Subject: FW: 24/00391/FUL - 21 Bartlett Road, Redditch - Lister Tube

Attachments: Design and Access Statement .pdf, P-01 Site Location Plan-A3 Sheet (2).pdf, P-05 Proposed Site Block Plan-A3 Sheet (2).pdf

Location Plan

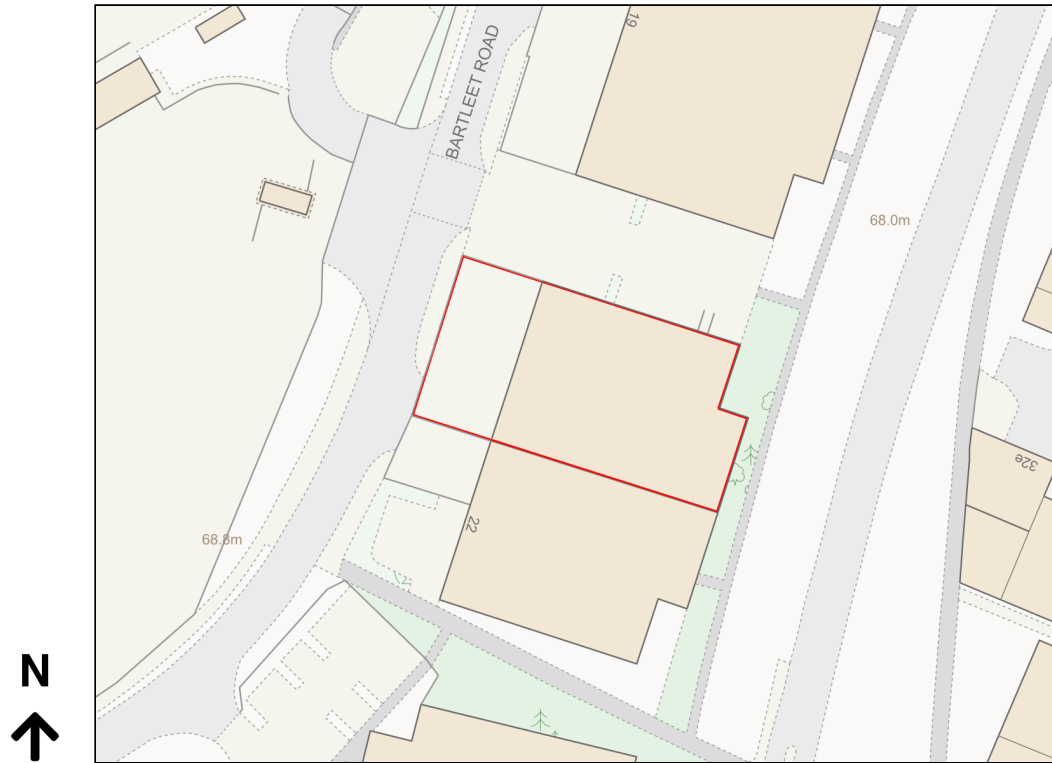
In terms of application completeness, it appears that the applicant owns additional land to the north-east of the site which I understand may be used for parking of employees and customers which if this is the case needs to be identified in edge in blue in accordance with the advice on the Council's web site, snipped below

It was good to speak with you yesterday, please see attached revised site location & proposed block plans showing the blue line as discussed. I have also shown parking bays on the proposed block plan. Please see also a revised DAS, it has been revised to include a brief statement about the on site parking facilities.
